**Consultation Response from KC,
Lead Local Flood Authority**

2026/90435 Land Off, Cockley Hill Lane, Kirkheaton, Huddersfield, HD5 0HH

**Date Responded: 25th May 2026
Responding Officer: Paul Farndale
Responding Ref: 2**

TITLE	
PROPOSED BASIN DETAILS	
PROJECT	
COCKLEY HILL, KIRKHEATON	
CLIENT	
GLEESON HOMES	
DRAWING STATUS	
PRELIMINARY	
Scale	Date
AS SHOWN @ A1	NOV 25
Drawn	IC
Chk.	MI
Org. No.	Rev
2181/07/13.01	A

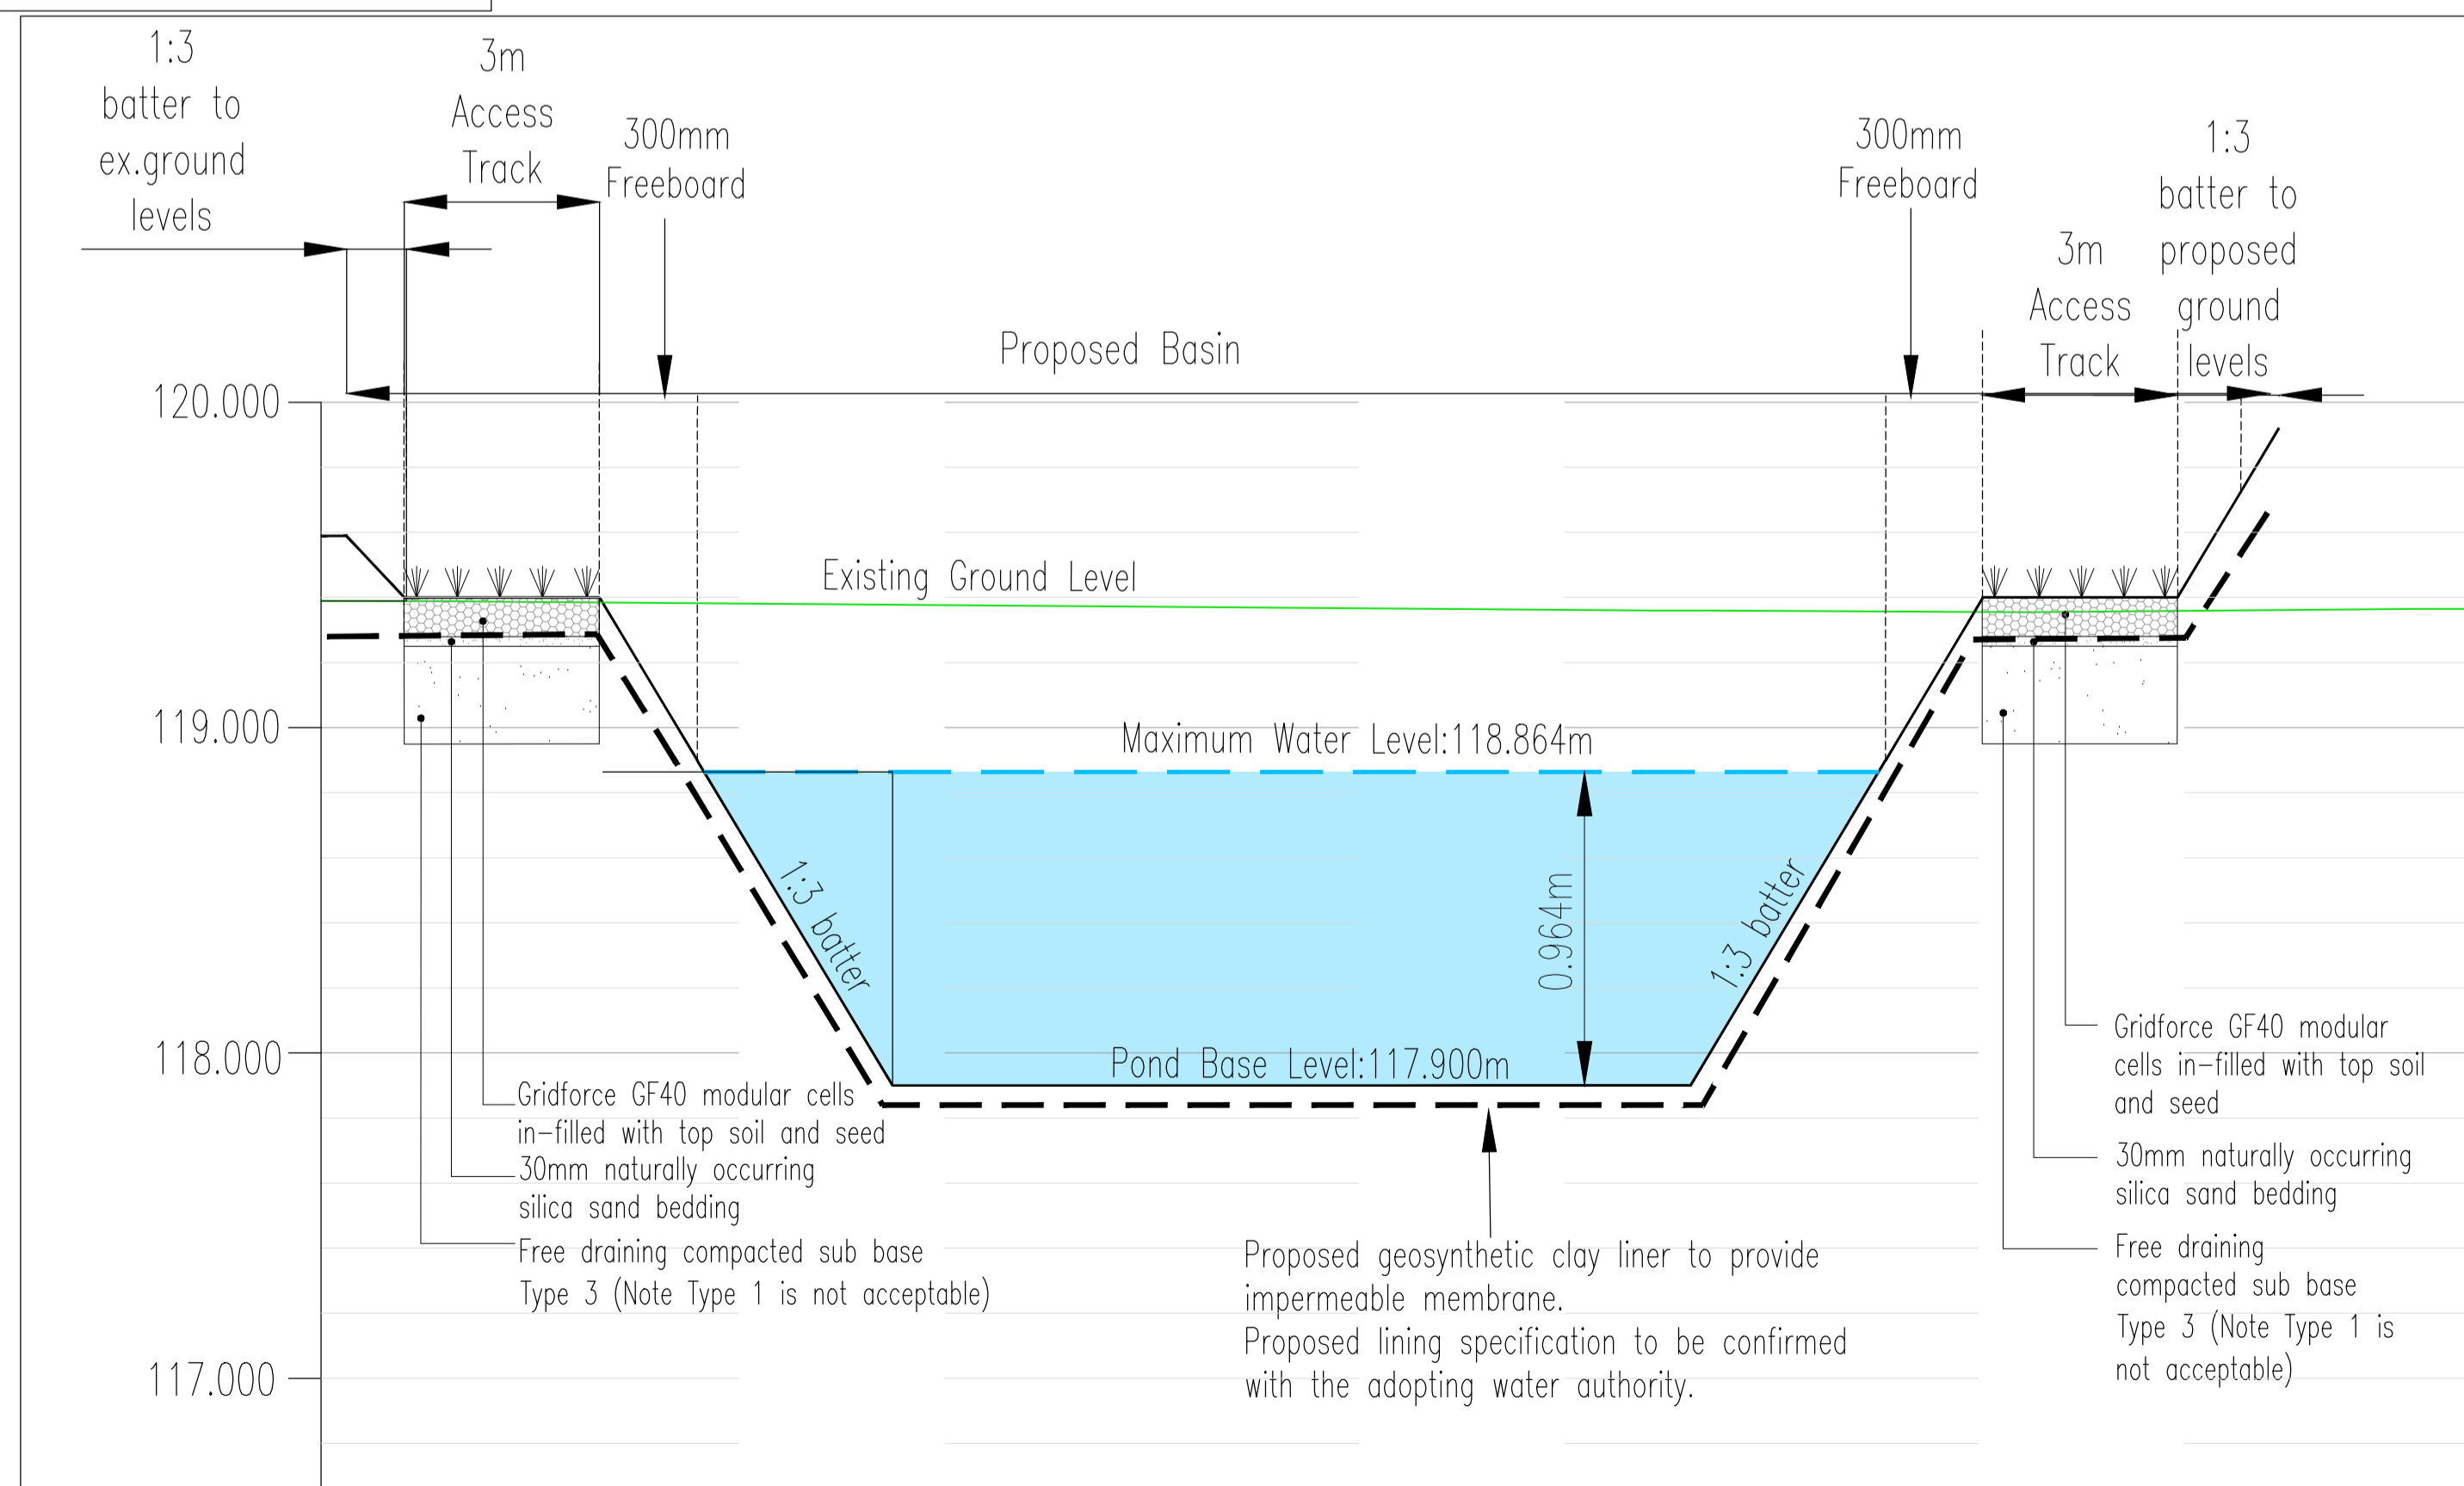
A drainage layout, basin design and impermeable area plan have previously been submitted.

Subsequently supporting hydraulic calculations plans and a maintenance schedule and itinerary has been included.

The maintenance plan needs to be coupled with the management company agreed to be set up under section 106 (Town & Country Planning Act 1990), with a break clause for when surface water infrastructure is adopted.

We can now recommend that this condition be discharged.
